West Burton Solar Project

Statement of Common Ground with Environment Agency [Revision B \(Tracked\)](#)

PINS reference: EN010132

Document reference: [EX5EX6](#)/WB8.3.5_[AB](#)

Drawing file: EN010132 / EN010132-001113-WB6.4.4.1_A Figure 4.1 Illustrative Site Layout Plan West Burton 1_Revision A (Tracked).pdf

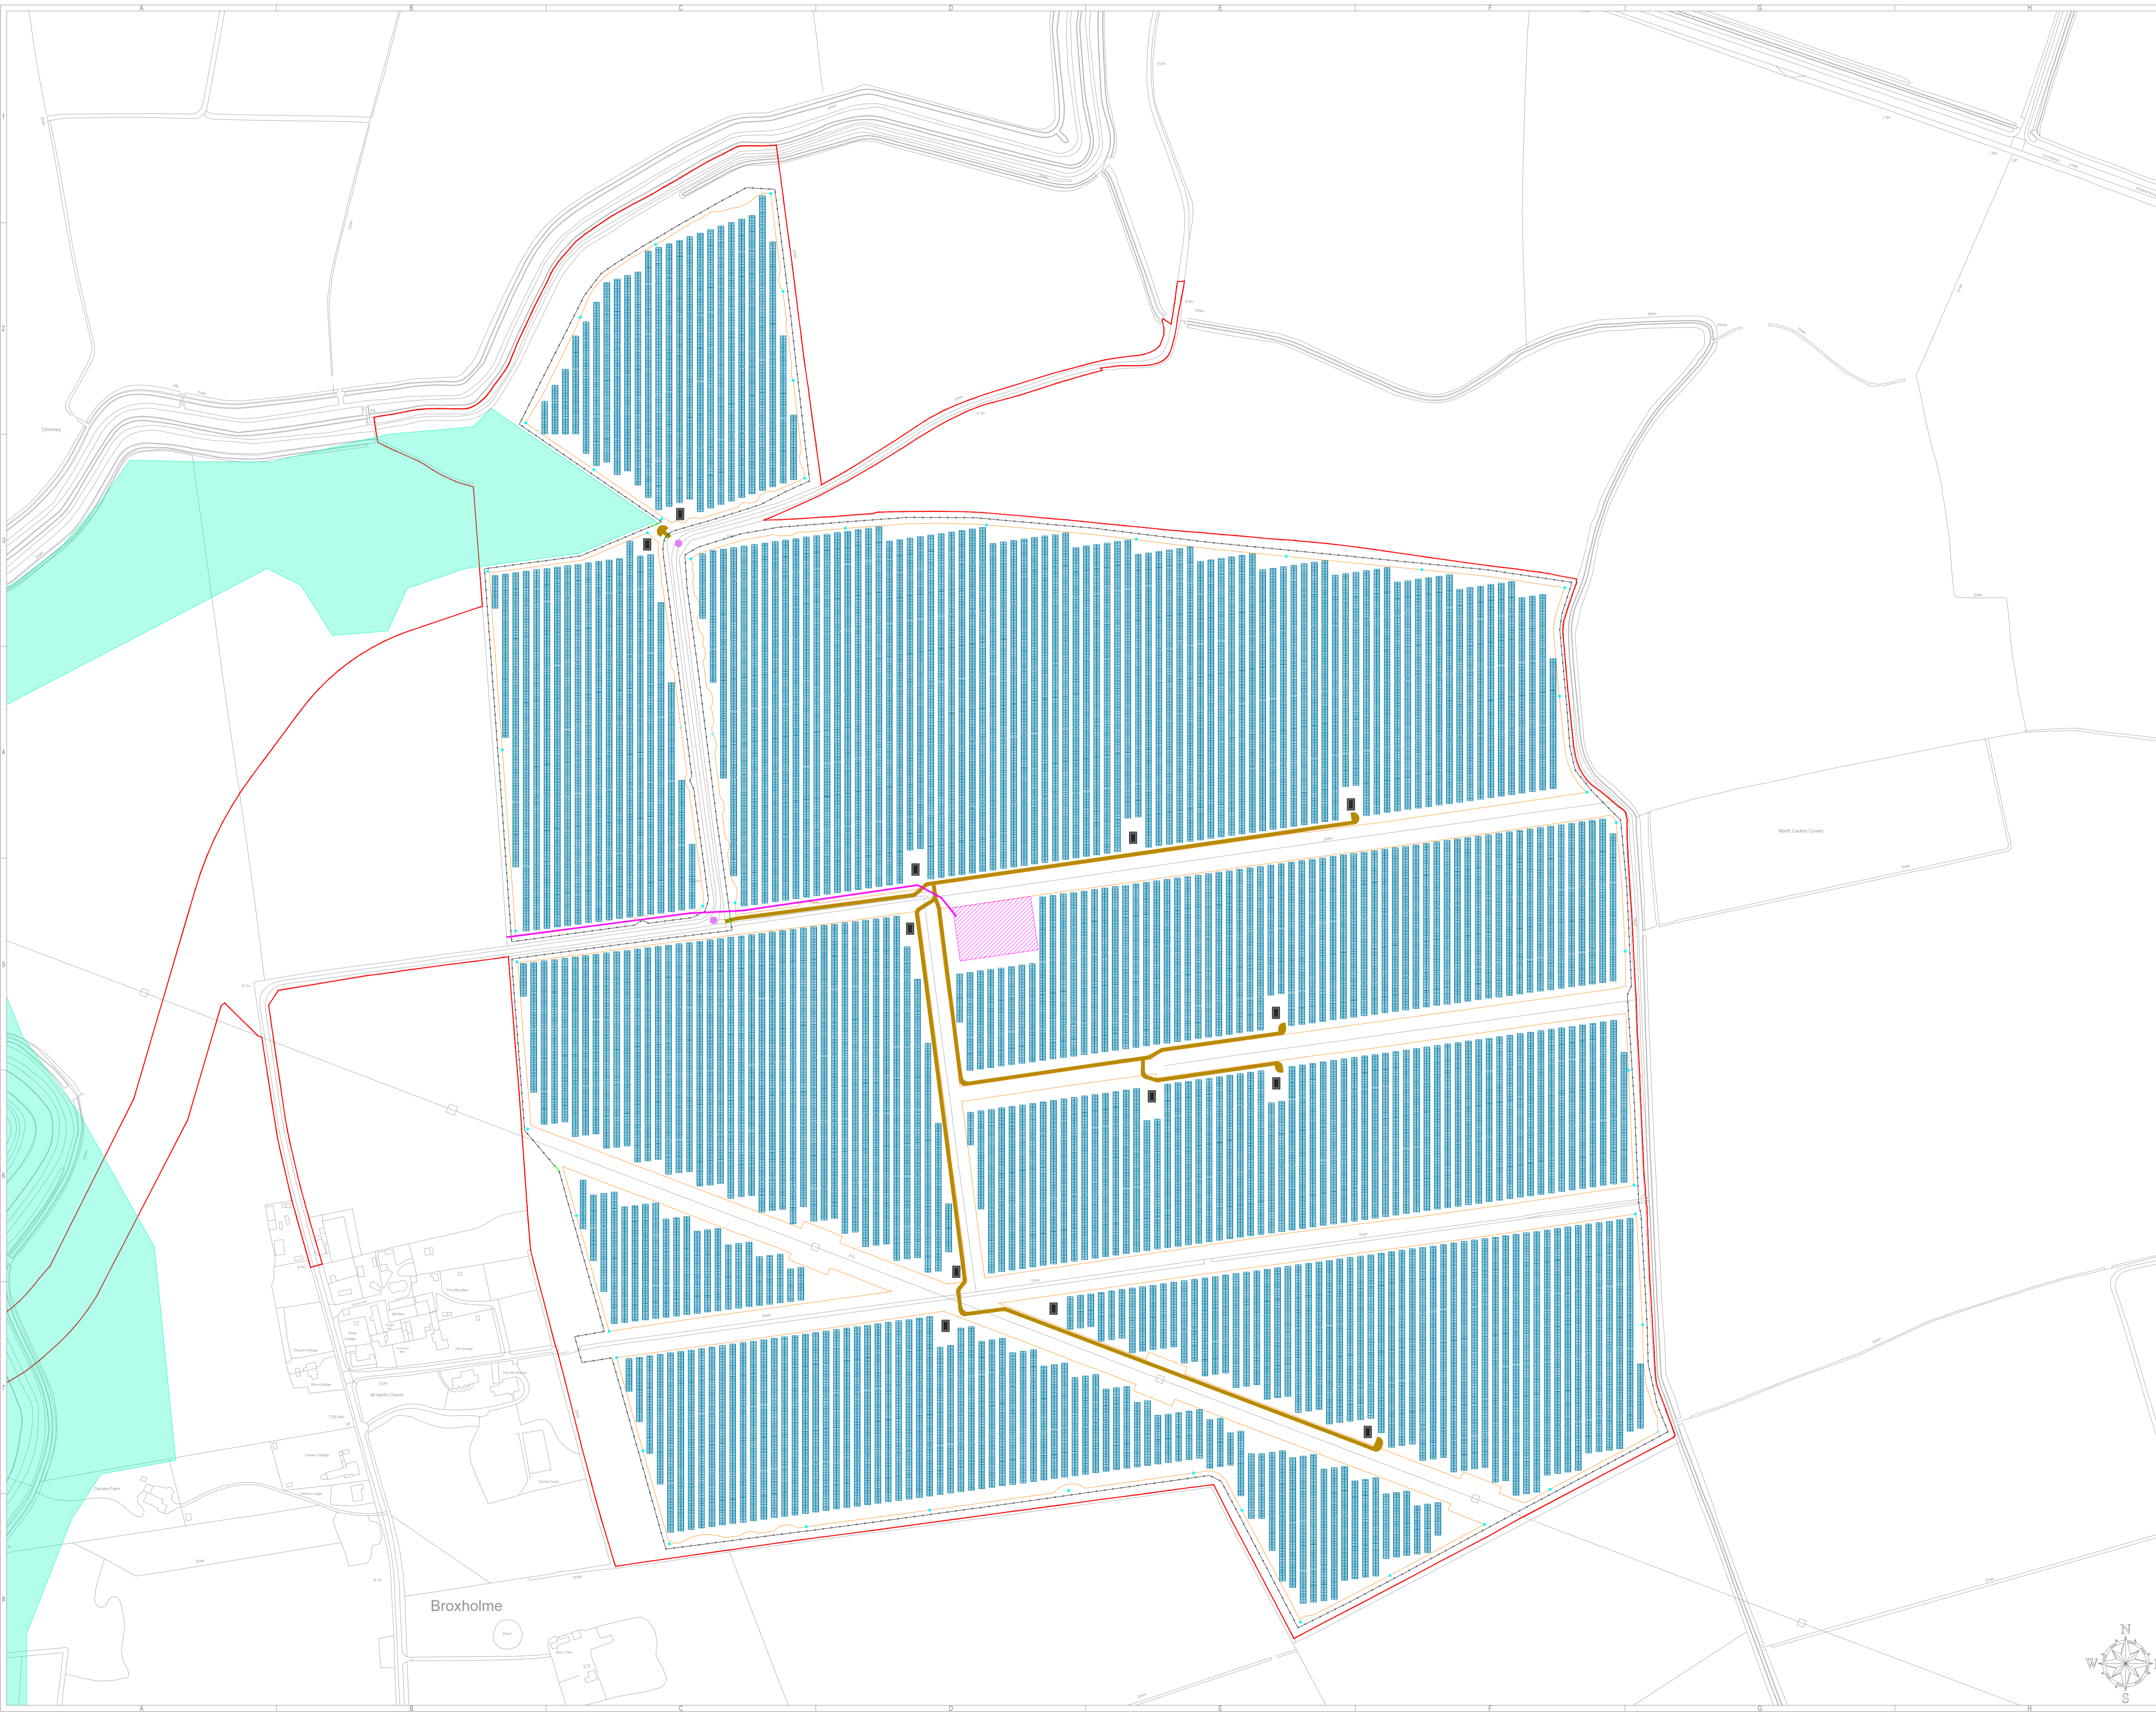
HFD-05 Hydrology, Flood Risk and Drainage	Layout	It is understood that no development will be situated within the River Till Flood Storage Area (FSA). For the avoidance of doubt, we would ask that the applicant overlay the River Till FSA outline onto the illustrative site layout plan and include it within Appendix 10.5 of the ES.	The Applicant notes this comment, but understands that Appendix 10.5 of the ES refers to West Burton 3, which does not include any part of the River Till FSA. The Applicant instead understands that the EA is referring to Appendices 10.3 and 10.4 of the ES. A plan overlaying the River Till FSA was submitted at Deadline [REP1-022 and REP1-024]
